CITY OF ALBUQUERQUE

March 29, 2016

**RE: Eagle Ranch Retail
Conceptual Grading and Drainage Plan
Engineer's Stamp Date 2-24-2016 (File: B13D002C)**

SHEET NUMBER  
**C-1.0**

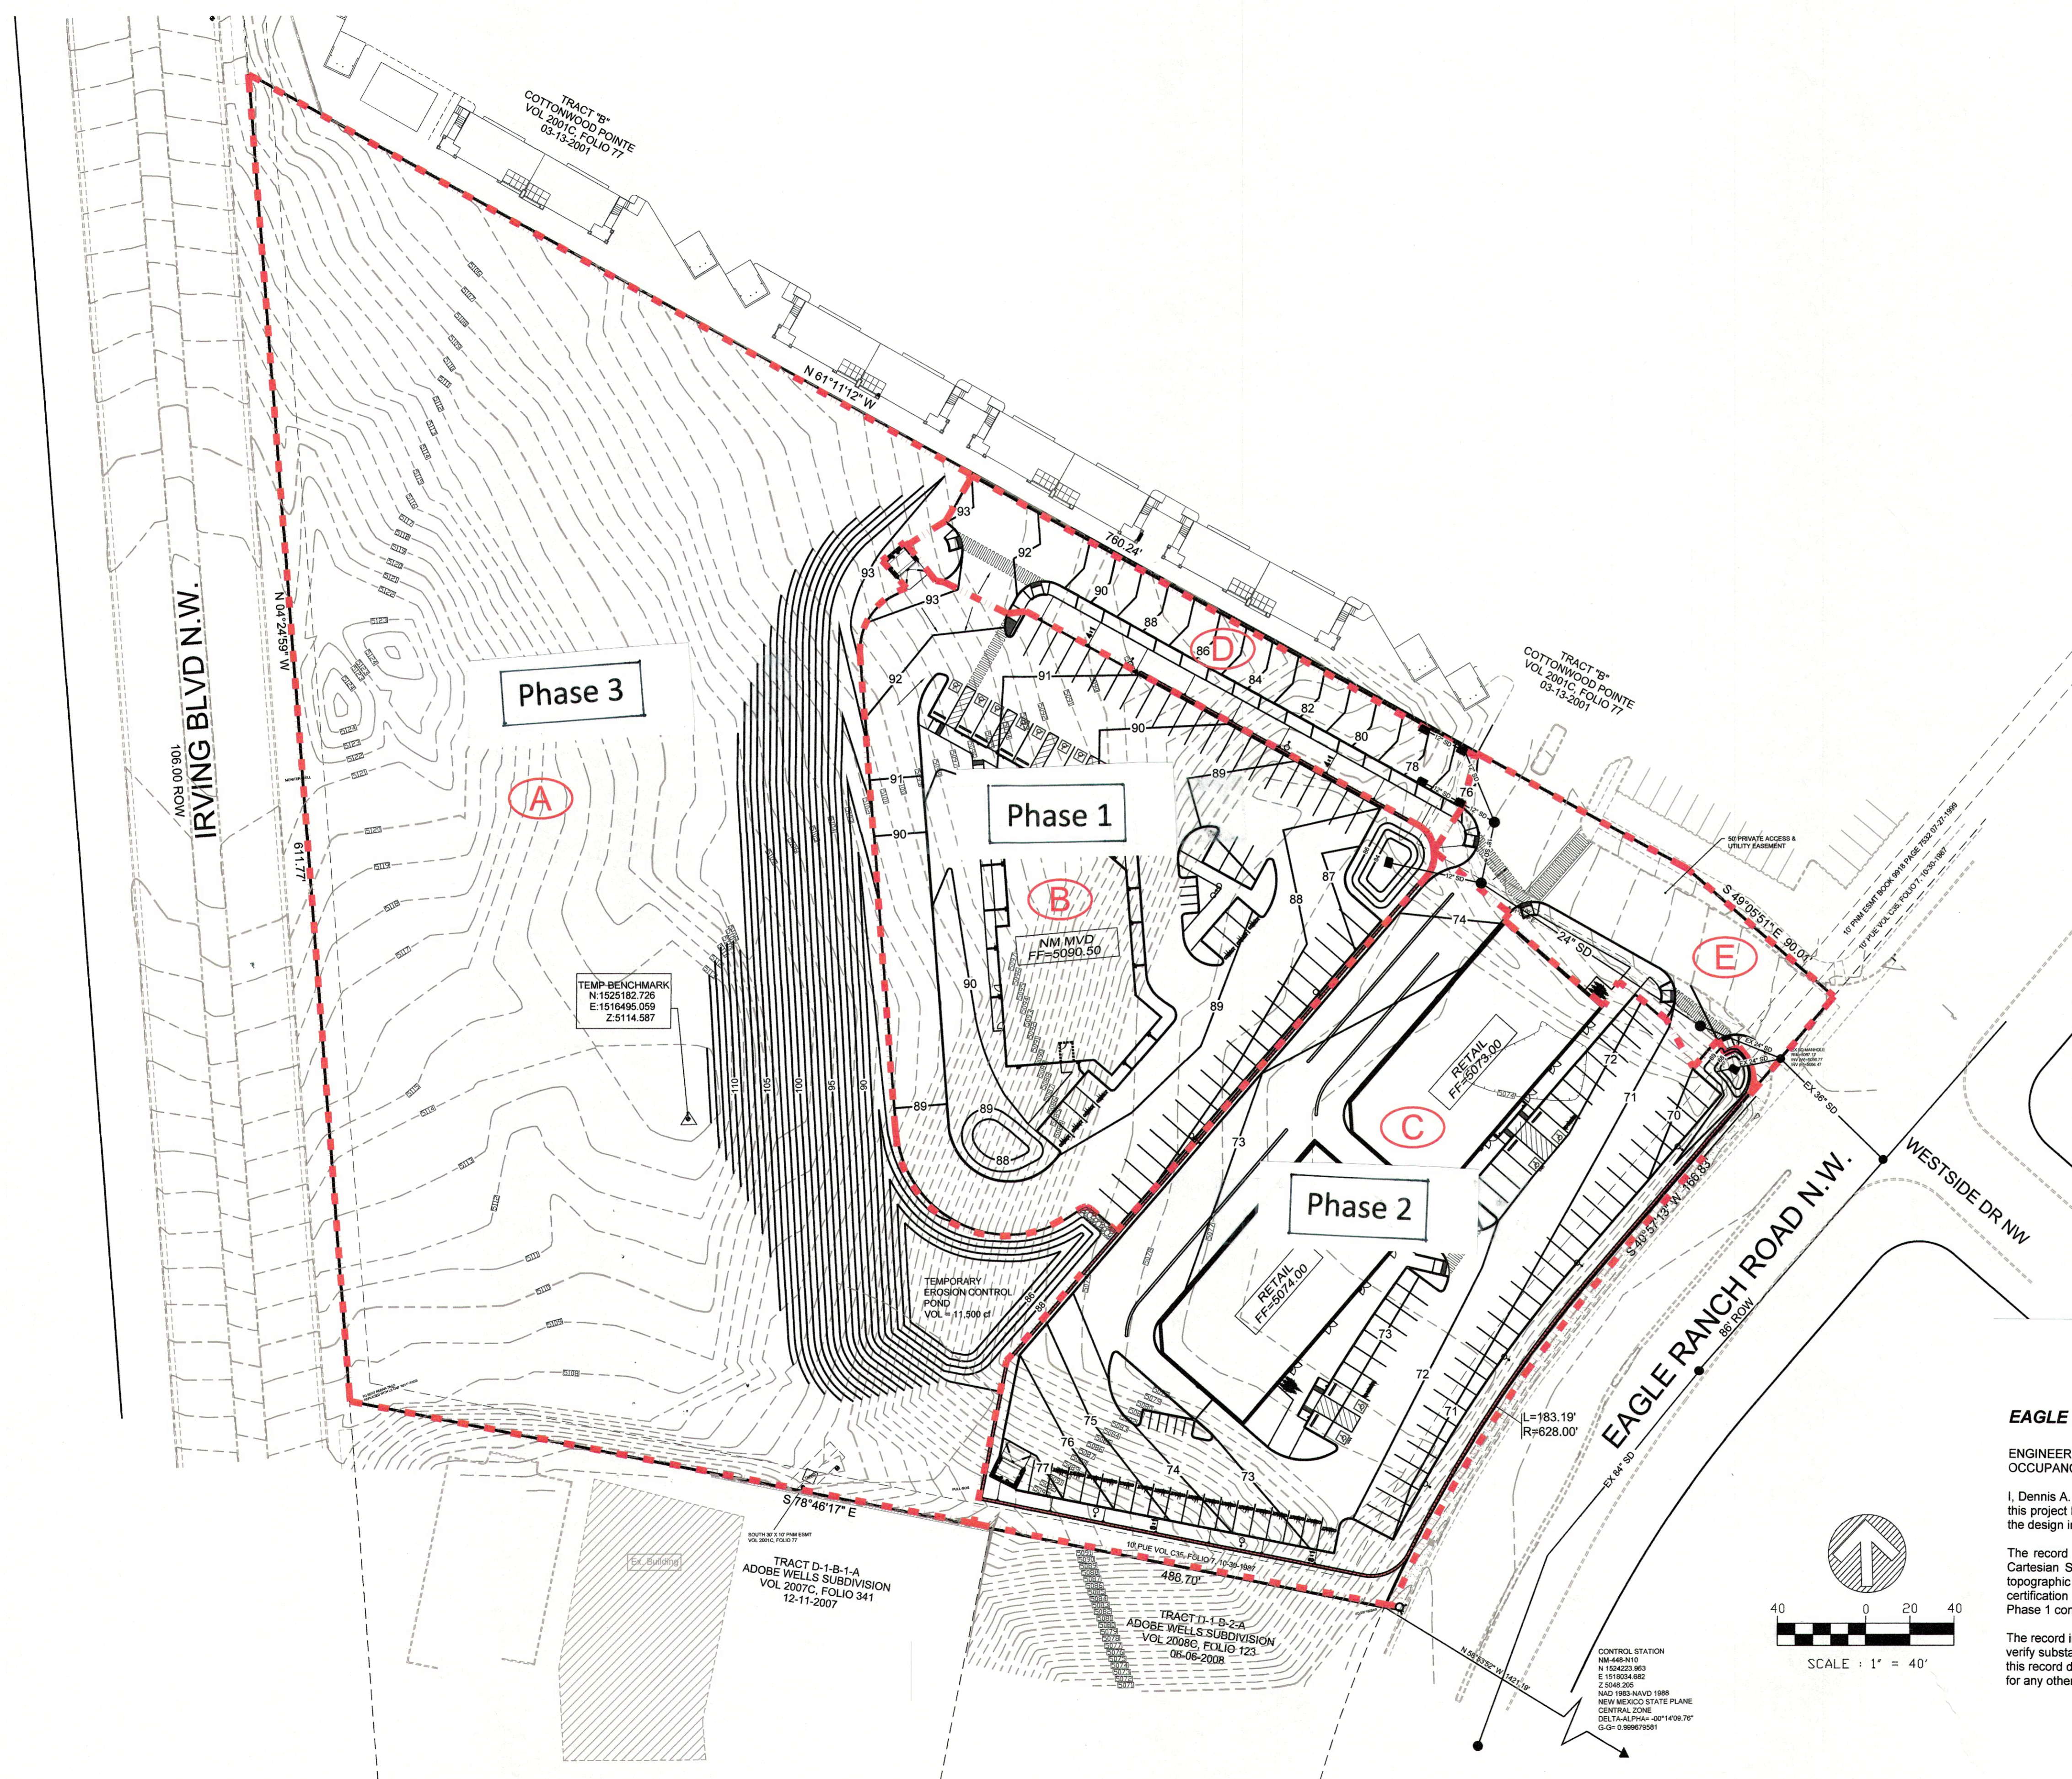
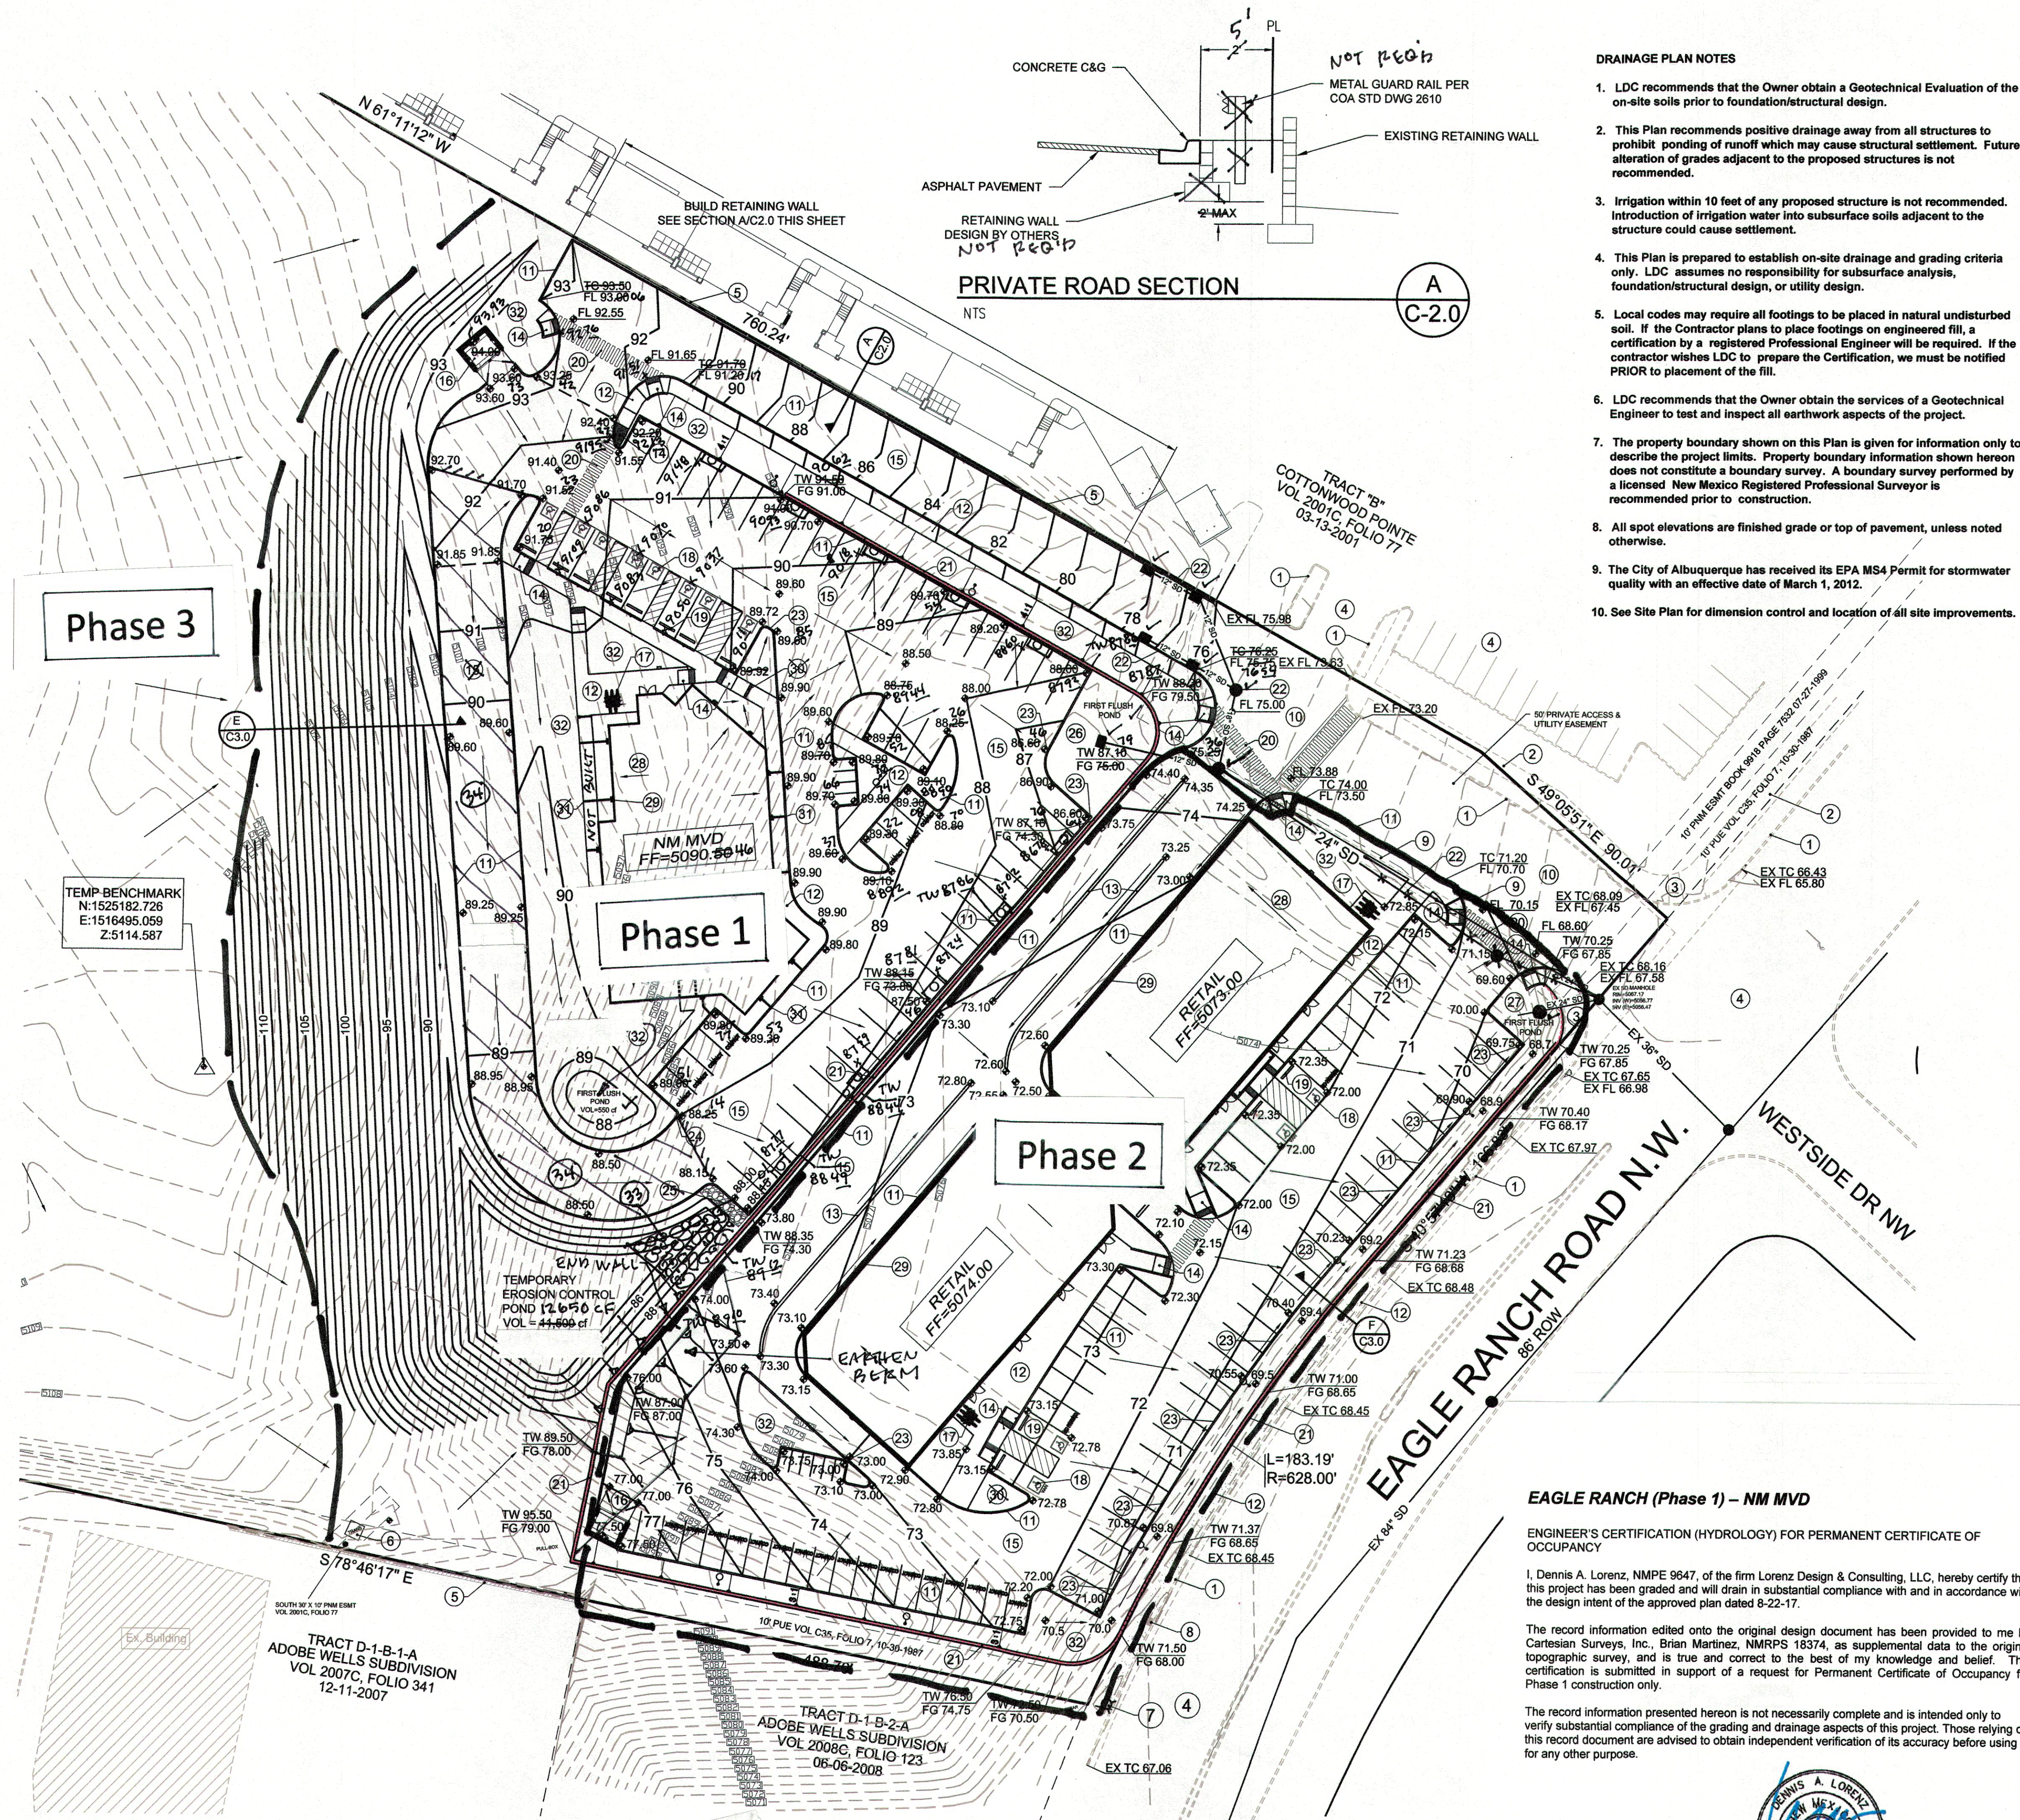
There is a minor typo in the order of the Keyed Notes (15 and 16); it can be addressed in the DRB submittal.
